From: Laura Gibbons
Sent: 13 February 2019 15:09
To: 'James Massingham'
Cc: Laura Humphries; Yuved Bheenick (Linden Homes); Gareth Hardwick; Michael Eastham
Subject: RE: Walberton - Today's Development Team Meeting

Thank you for sending through the additional information. I have the following comments:

A1 Scale	Date	Designed by
1:1000	12/10/2018	AS
Drawn by	Checked by	Approved by
AS	JC	GH
Drawing Number	183240-001	
Rev	H

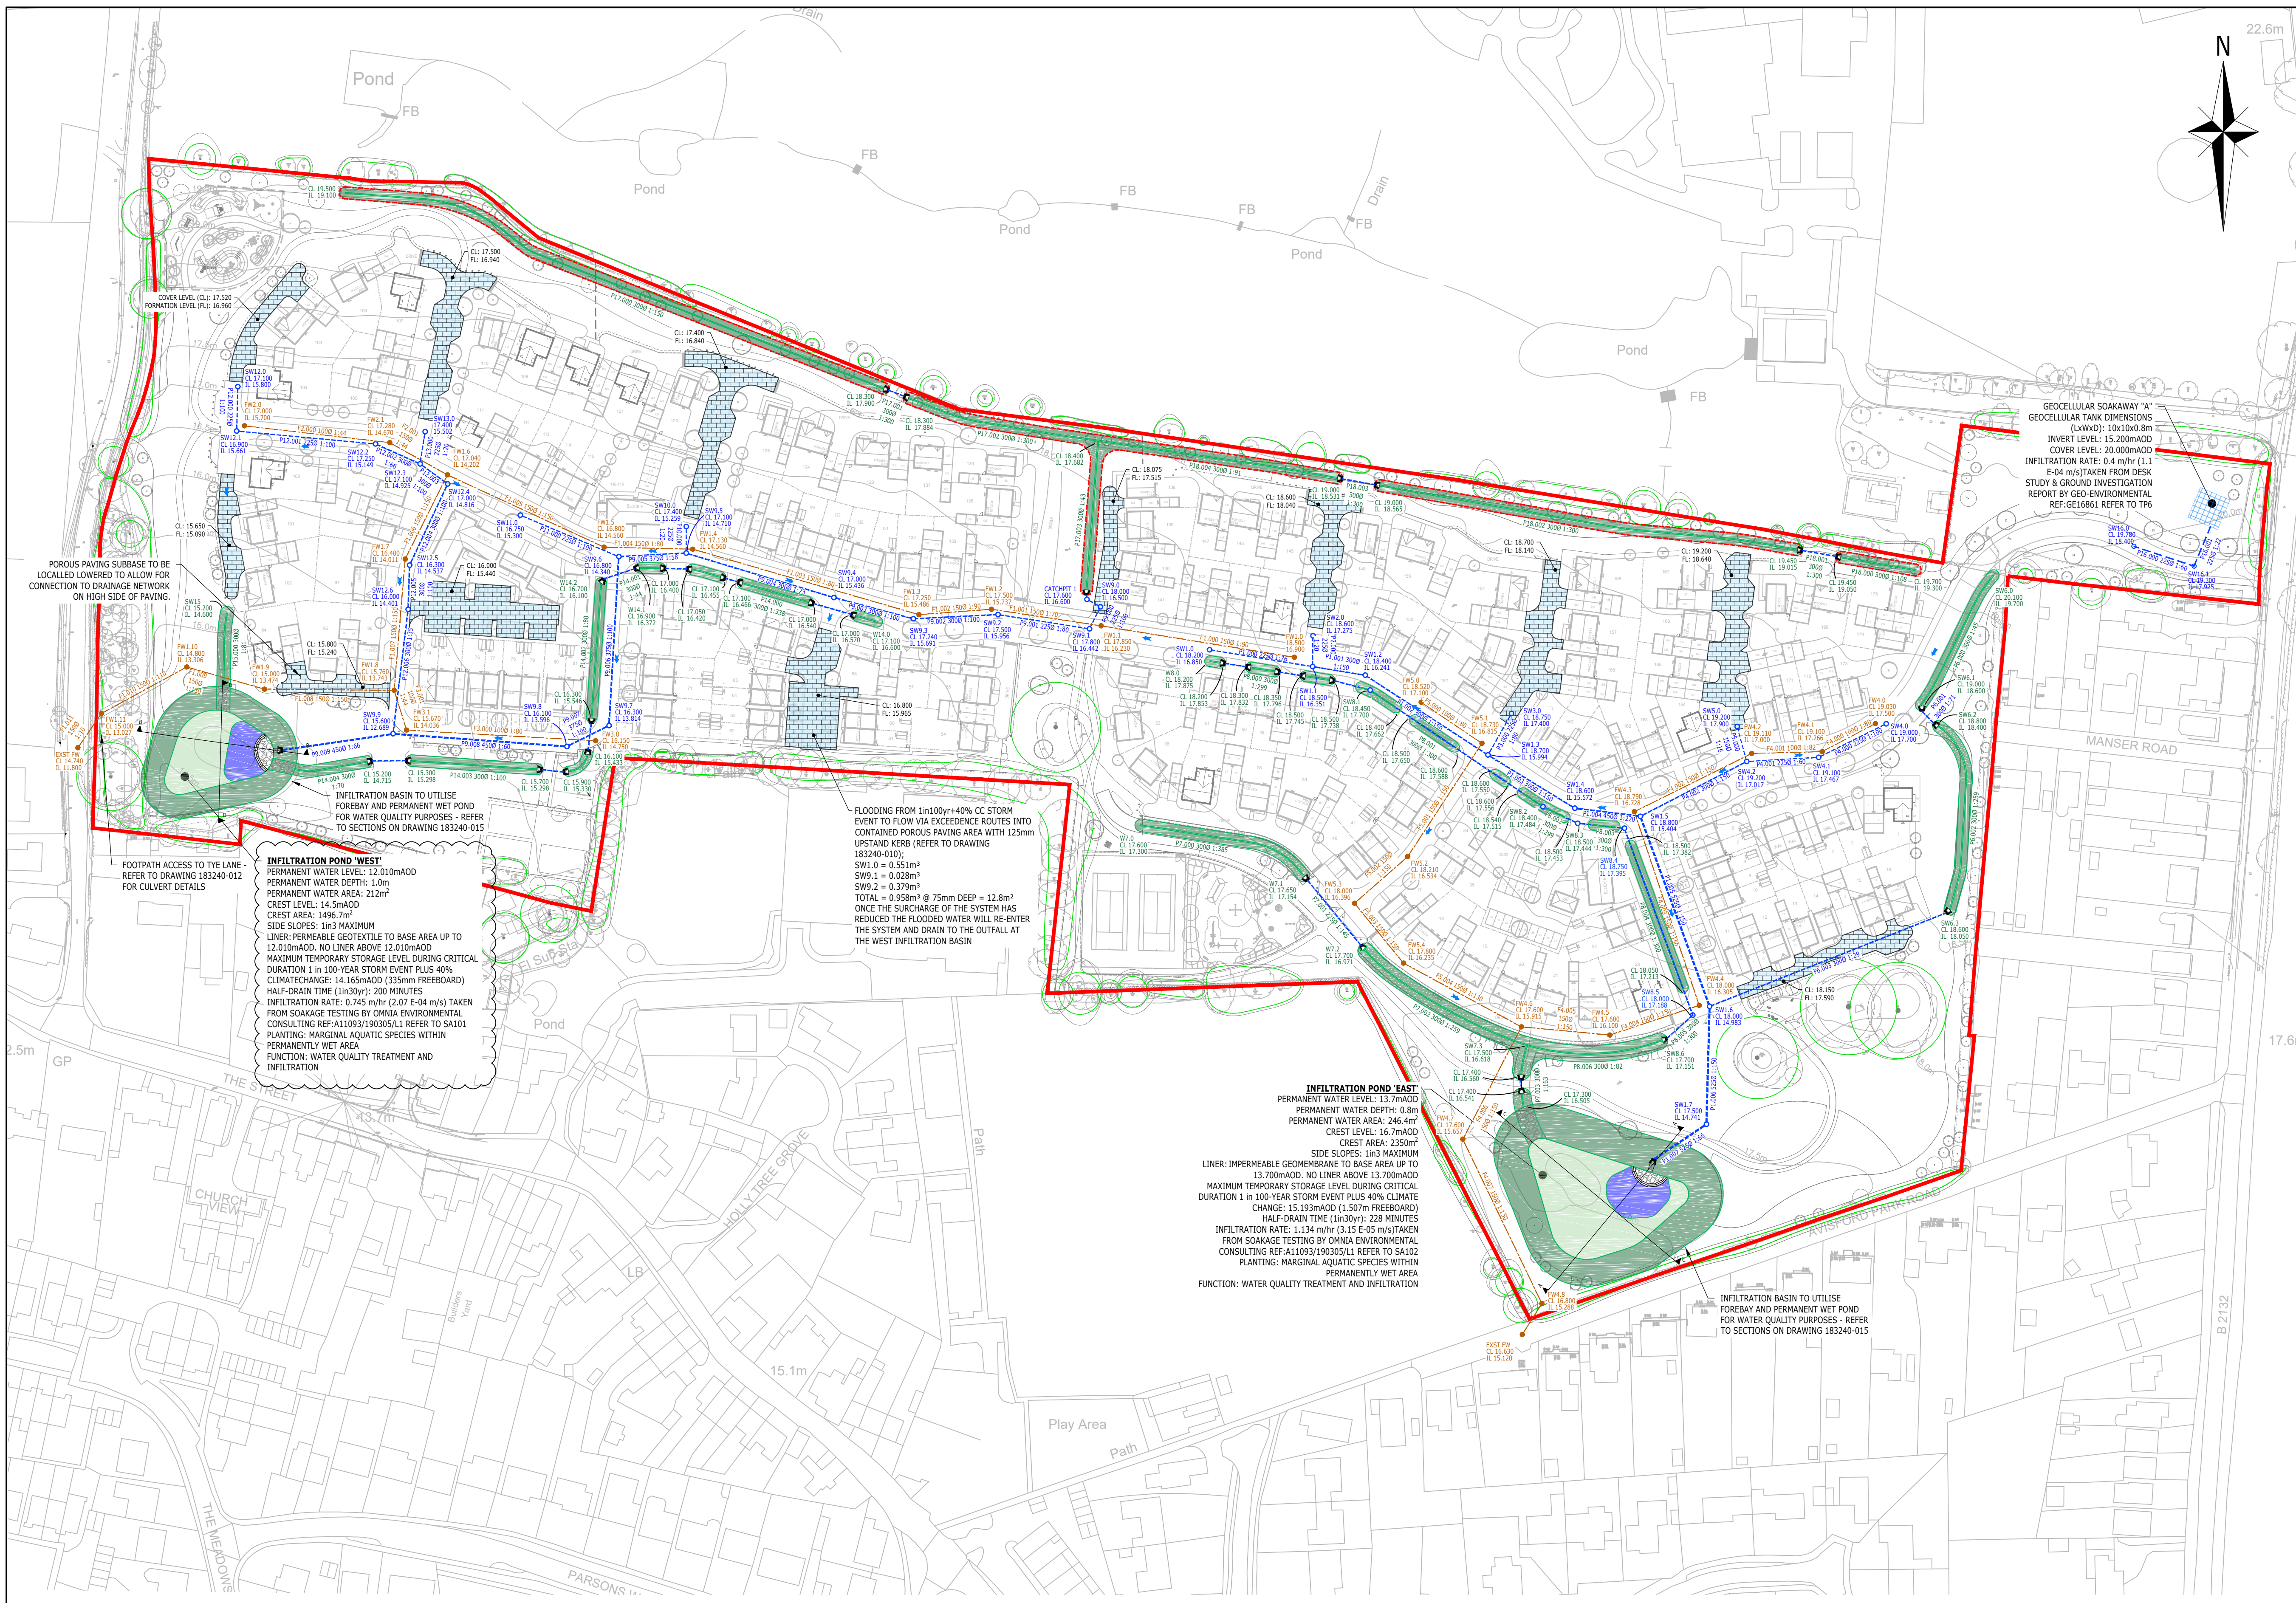
3. The proposals for the culvert along Tye Lane show that the culvert will be set to the existing invert level. The ditch needs to be cleared of vegetation and silt. Invert levels need to be provided of the upstream and downstream culverts. The appropriate invert level will be determined from this. A better location plan needs to be provided.

4. The construction details of permeable paving show that a type 1 sub base is specified. Type 1 is not permeable, please remove this to allow infiltration to occur where groundwater is not a concern. Where proposed formation levels are close to groundwater levels I am happy for the sub base to remain, i.e. the permeable paving near SW12.0 and SW13.0.

7. Invert level and bank elevations of swales need to be stated on plan.
8. There is a discrepancy between the cover level modelled and that shown on plan at SW9.3.

9. Please provide formation levels and finish levels on plan of the permeable paving.
10. The porous car park at SW9.4 has a finish level of 16.8mAOD, maximum water level at the node is 16.854, i.e. water is going to emanate onto the surface from the permeable paving area. There are also discrepancies at SW9.0, SW2.0 (modelled water depths don't appear to be a concern) and SW3.0 (modelled water depths don't appear to be a concern). Please ensure that the cover levels modelled are actually the lowest finish levels for respective areas of permeable paving.

11. The permeable paving at SW9.9 appears to fall away from the connection, please reduce maximum volume depths to take account of this or revise formation levels.

14. Please can you provide me with details of the proposed kerb levels etc. where it is identified exceedance flow will ultimately end up. For example kerb levels around the permeable paving at SW9.4.

15. I cannot see a note on the drawings that states that Linden homes have riparian responsibility for the ditch in Tye Lane and that they will clear it of vegetation and silt. Notes should be added to drawings to reflect this.

16. The invert level of the infiltrating areas of the ponds is the same as the incoming pipe invert levels. I would like to see a minimum of 150mm between these levels. Please revise details and calculations to reflect this. And please ensure that the invert level of the incoming pipe is provided on the pond cross sections.

17. Please can you provide two further cross sections of the ponds, i.e. one perpendicular to A-A and one perpendicular to B-B.
18. Please provide site specific swale drawings. Some swales may need to be lined in areas of high groundwater.

183240-011

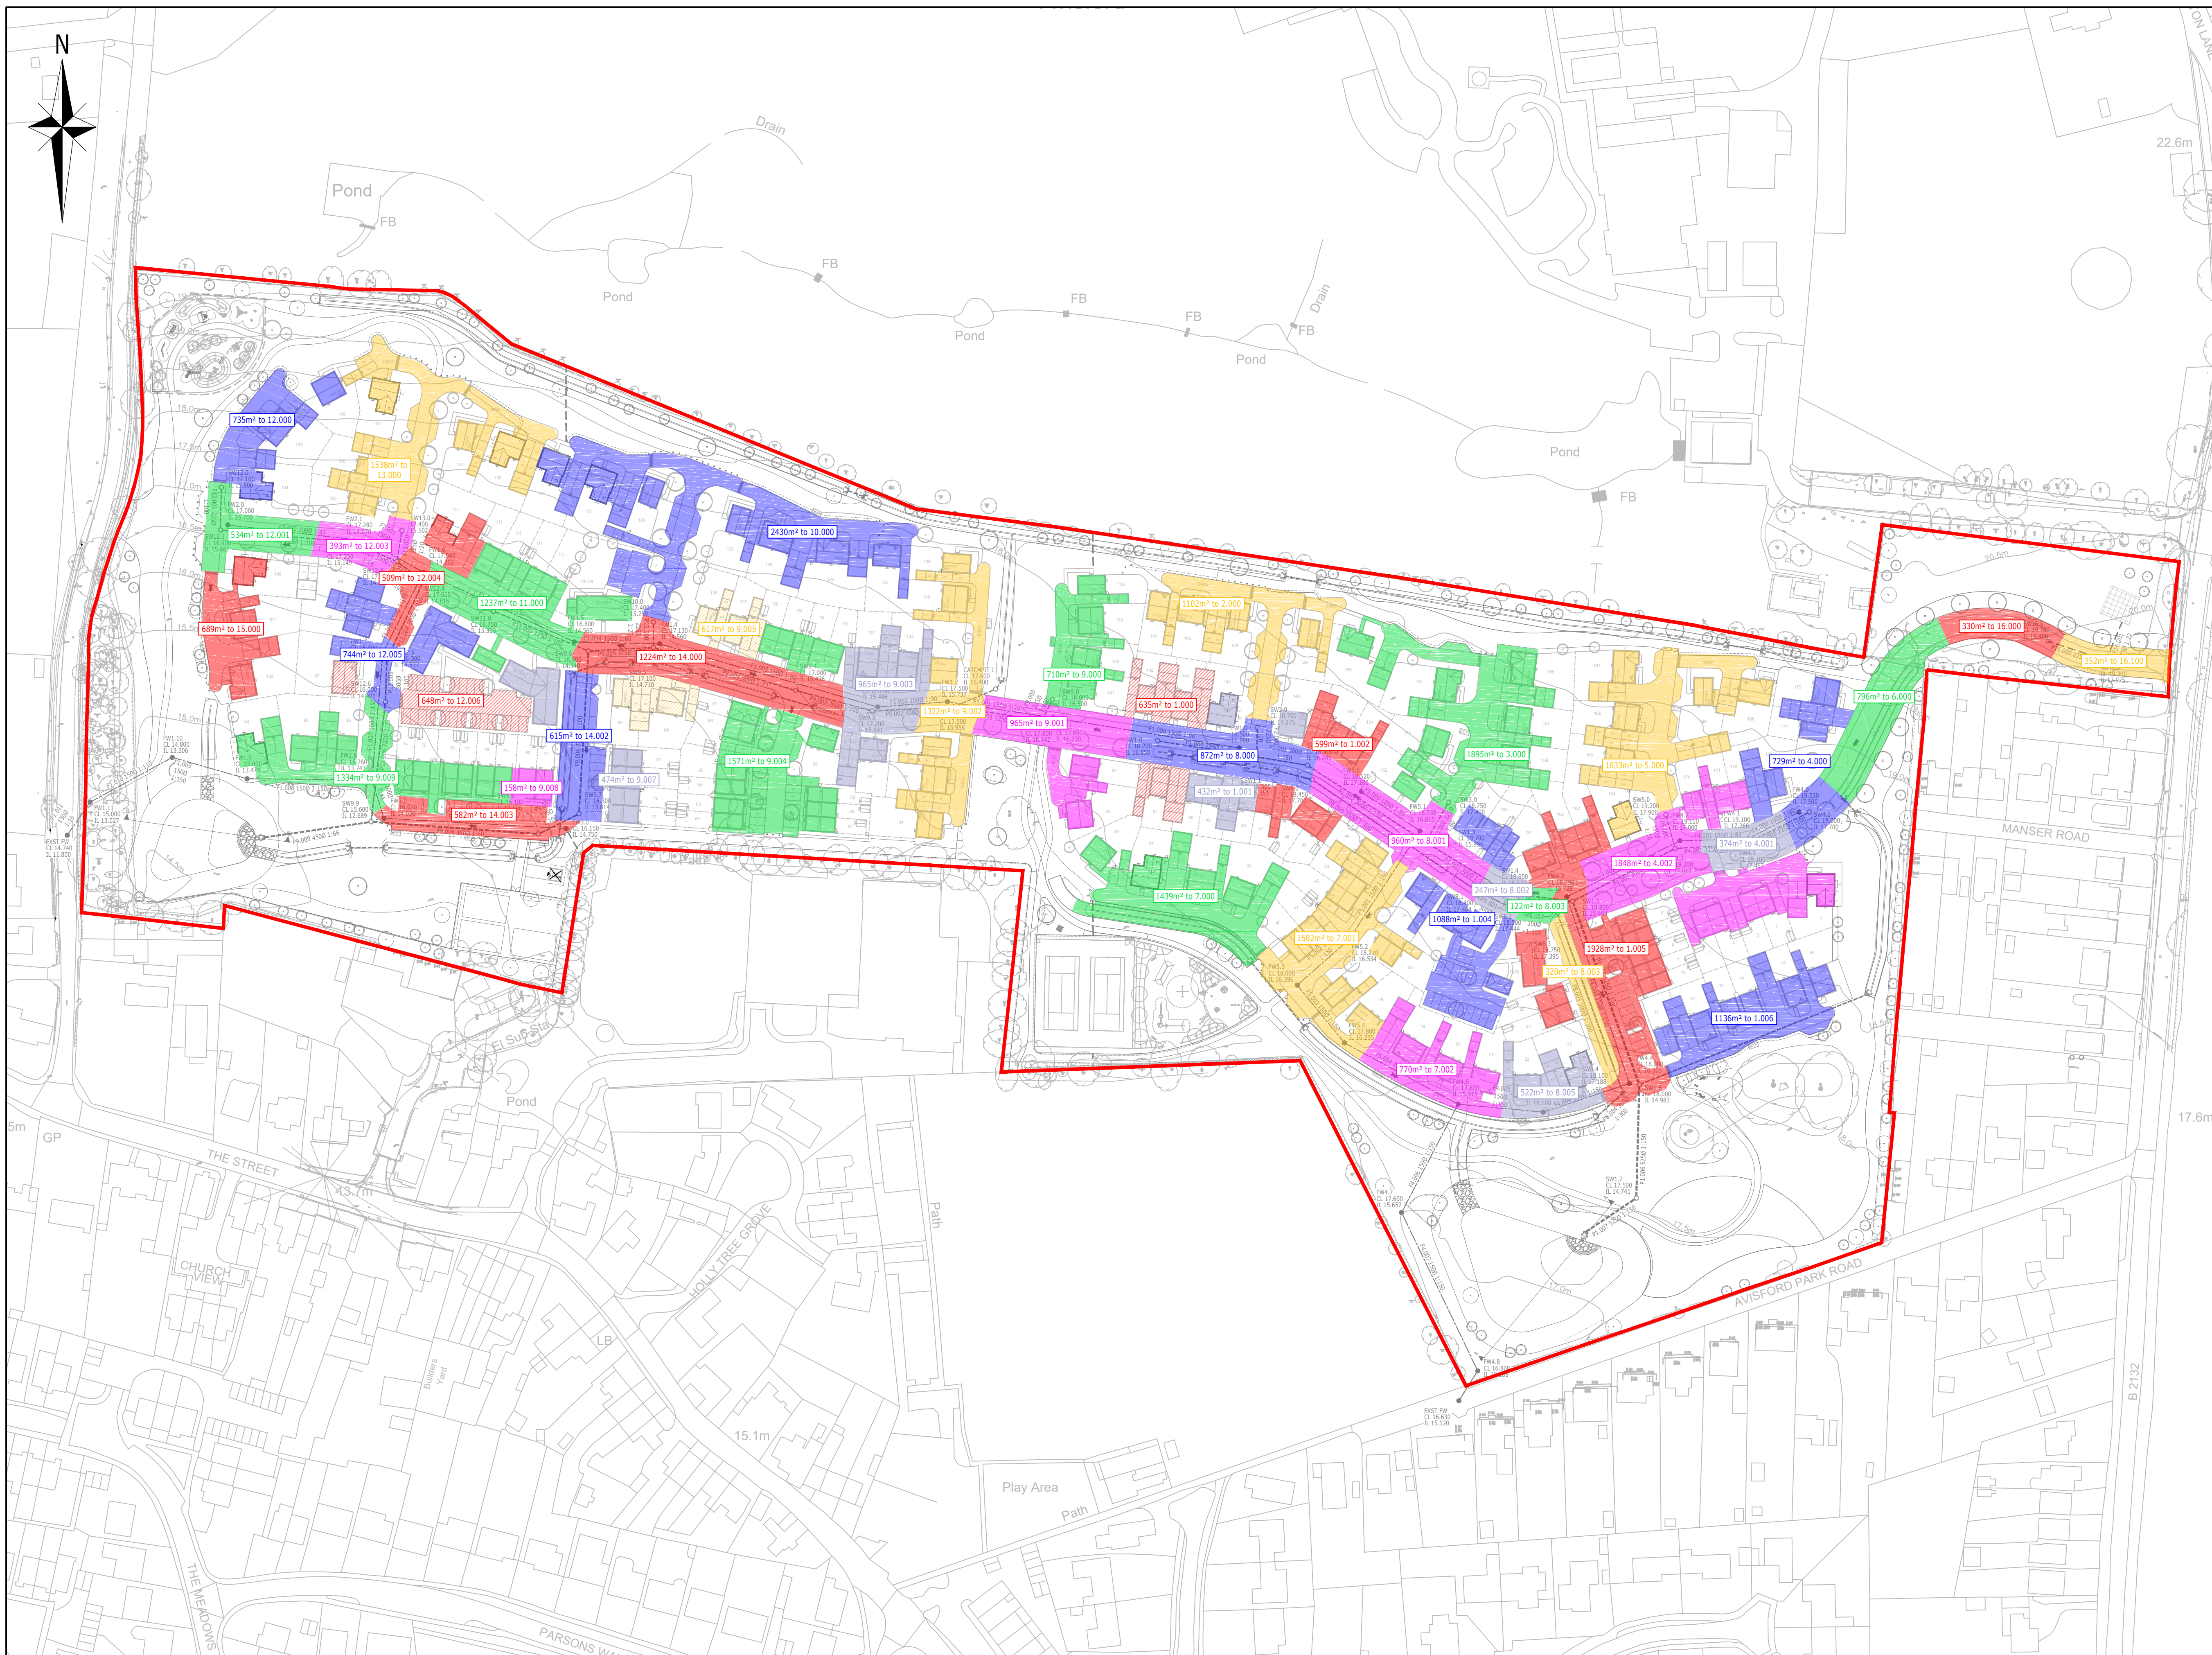
5. A 10% allowance for urbanisation needs to be applied to the impermeable areas.
6. The water falling directly onto the ponds should also be included, i.e. treat these areas as impermeable please.
